2024/0686

Address: 17 Withens Court, Staincross, Barnsley, S75 6HY

Description: Replace existing attached garage with 2 storey side extension with integral garage to 2 storey semi-detached property

PROPOSED SIDE ELEVATION
1:50

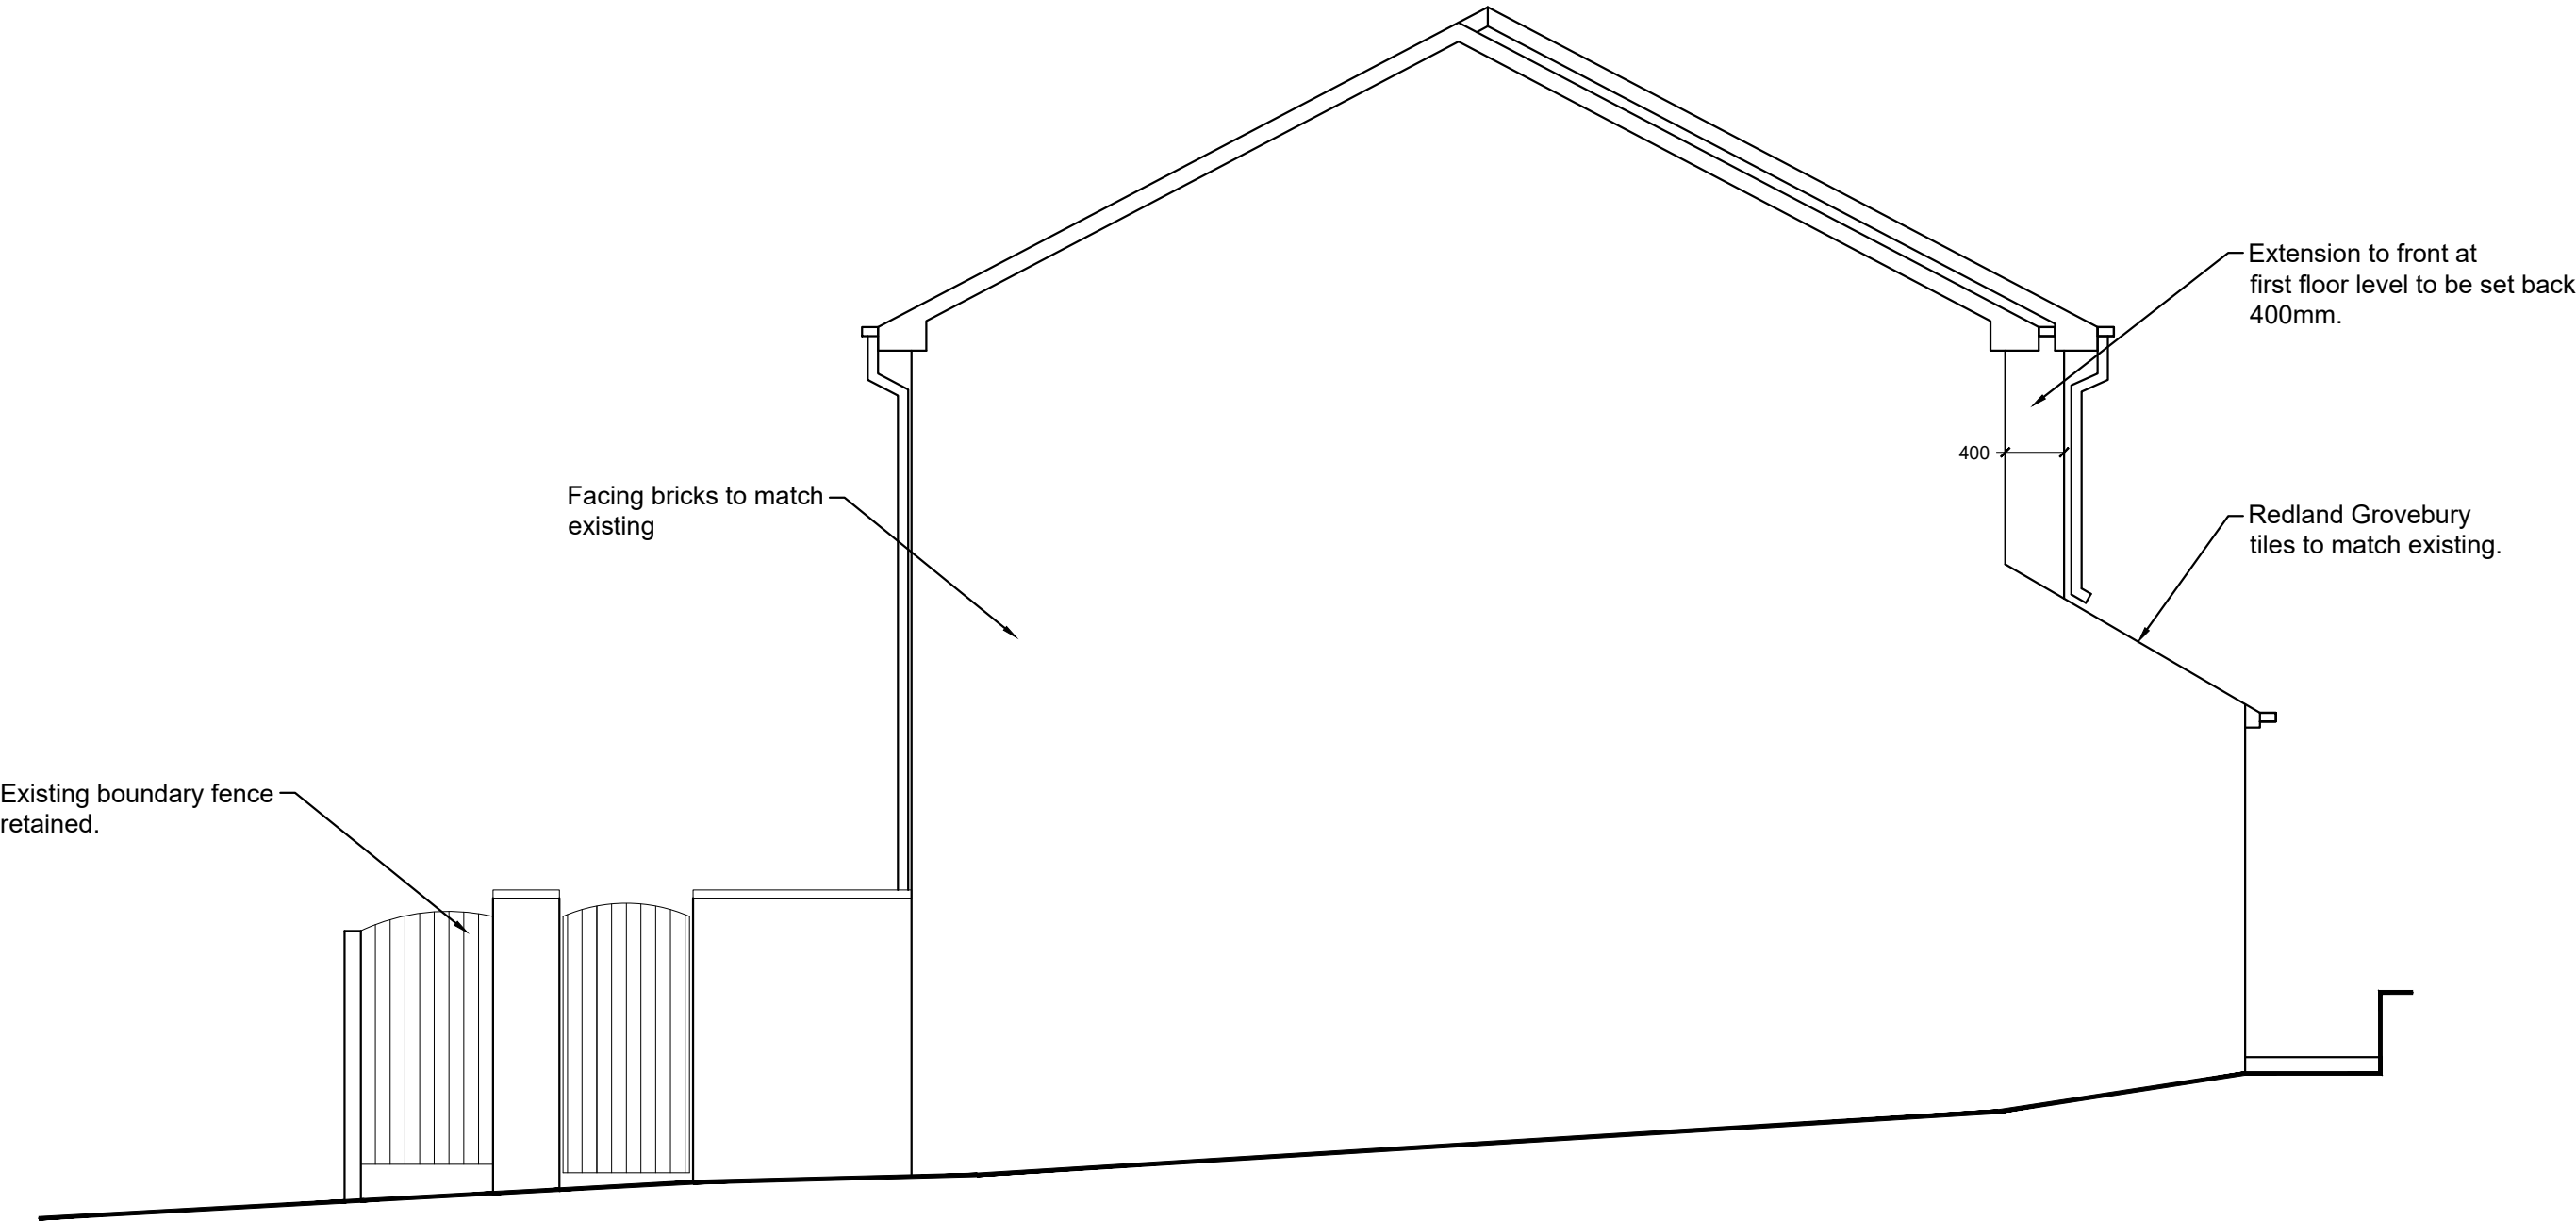
Where the original plans failed to meet policy requirements for visual amenity, the revised plans have provided improvements much more in line with policy guidance. A set back has been included within the first floor of the extension and a modest step-down of the roof has also been included. Mitigation for the plans not meeting the full policy guidance can be found in the land levels of the dwelling, with the significant level differences in the front and rear elevations, which may make a further step down of the roof difficult to incorporate. Additionally, due to the design of the pair of semi-detached houses, the attached neighbouring dwelling's roof is set much lower than the application dwelling, appearing at first glance to a subordinate extension to the application dwelling, rather than a separate house. With matching materials proposed and proposed reuse of the existing roller garage door, there would be minimal impact to the character of the dwelling or its impact within the street scene.

PROPOSED GROUND FLOOR PLAN
1:50

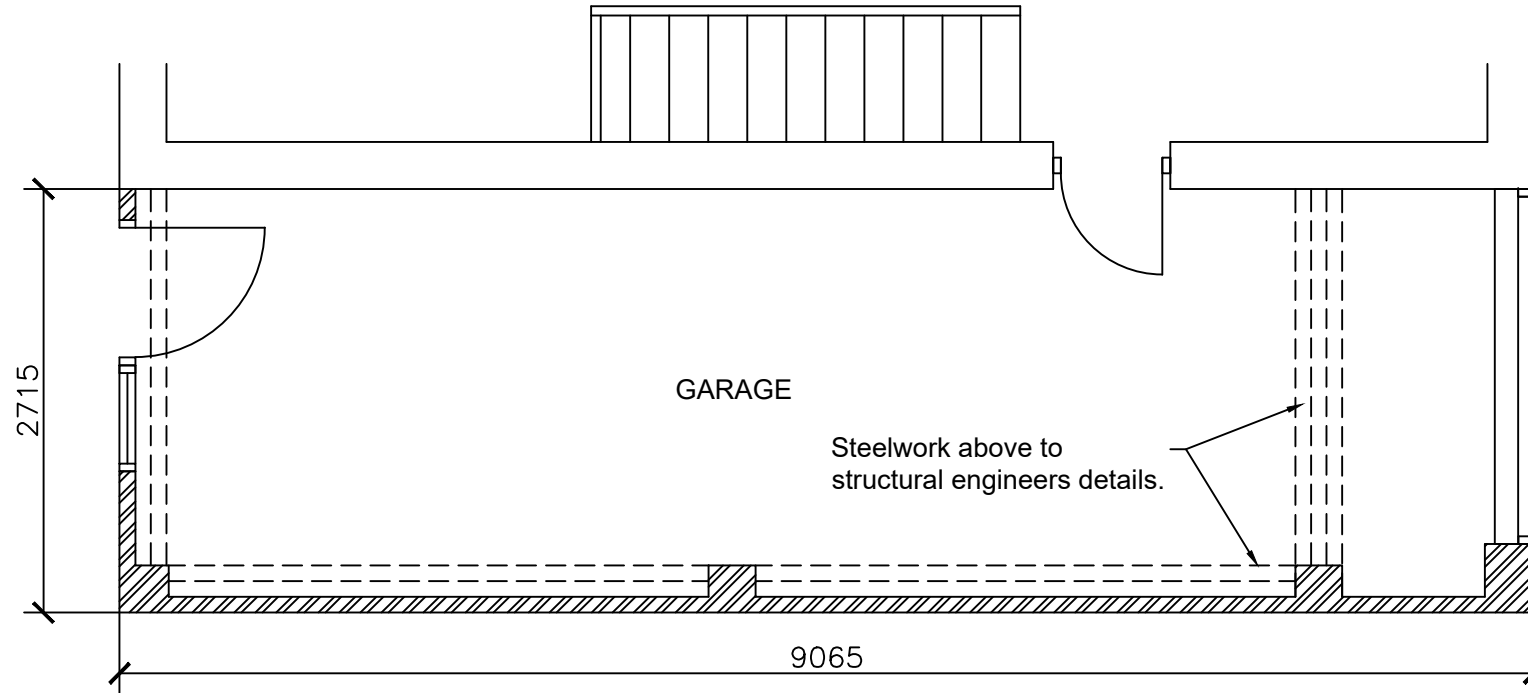
Highways DC: Although the width of the garage is slightly shorter than would usually be required, with the increased length of the garage, it has been deemed that the proposal would be acceptable subject to the existing or a replacement roller shutter garage door being retained as this would allow additional parking on the driveway to meet the policy requirement for two parking spaces.
